Subject: FW: LU/45/21/DOC - Cornfield Close

Subject: FW: LU/45/21/DOC - Cornfield Close and LU/42/21/PL - Riverside

In relation to the Verification Report (ref.: GE18103/VR/JAN21, dated January 2021) submitted in relation to the above, whilst the majority of the report seems satisfactory, there are some discrepancies which will please need to be clarified before EH can provide a complete response. For ease, these queries are detailed below:

Plate 3 – Infills Plot 11

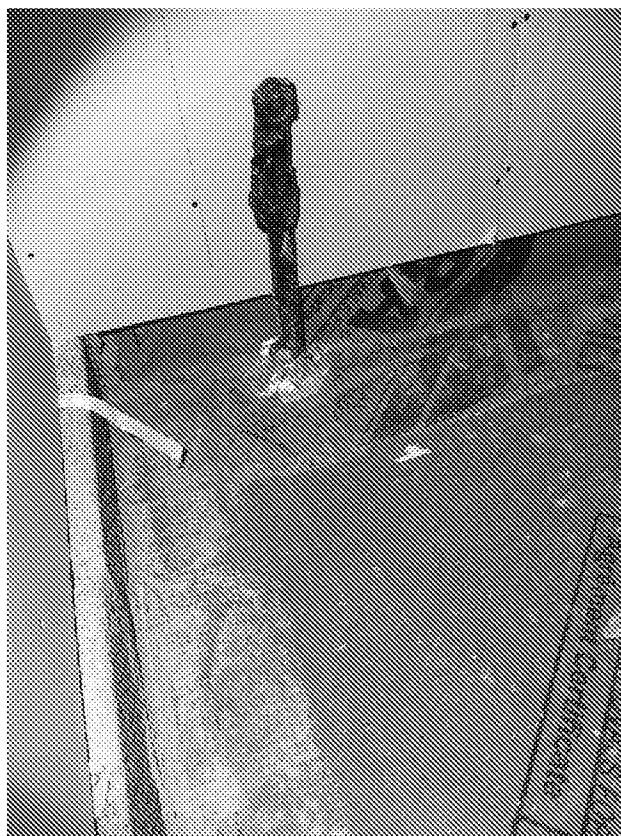
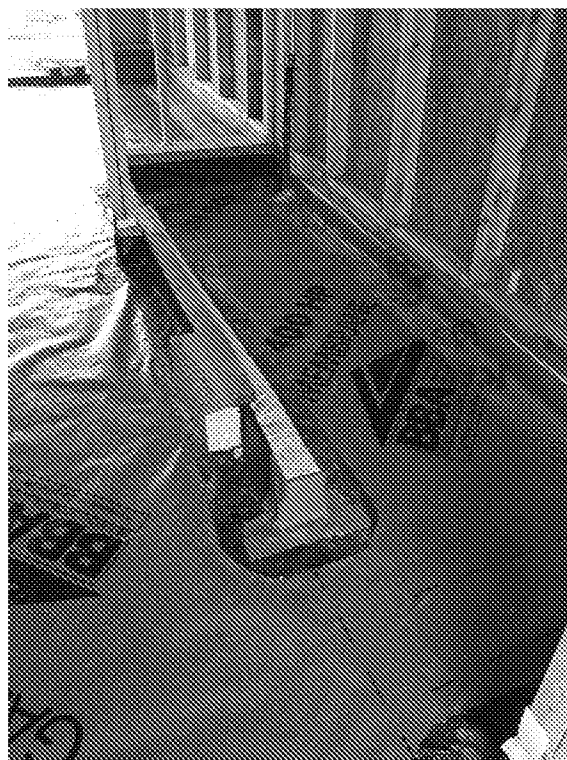
- are the consultants satisfied with the gas protection measures installed? It is understood that Plots 11, 14 and 15 were incomplete at the point of publication, although photographs of the subsequent completion were provided by the applicant's representative.
- ref to sampling by Bell
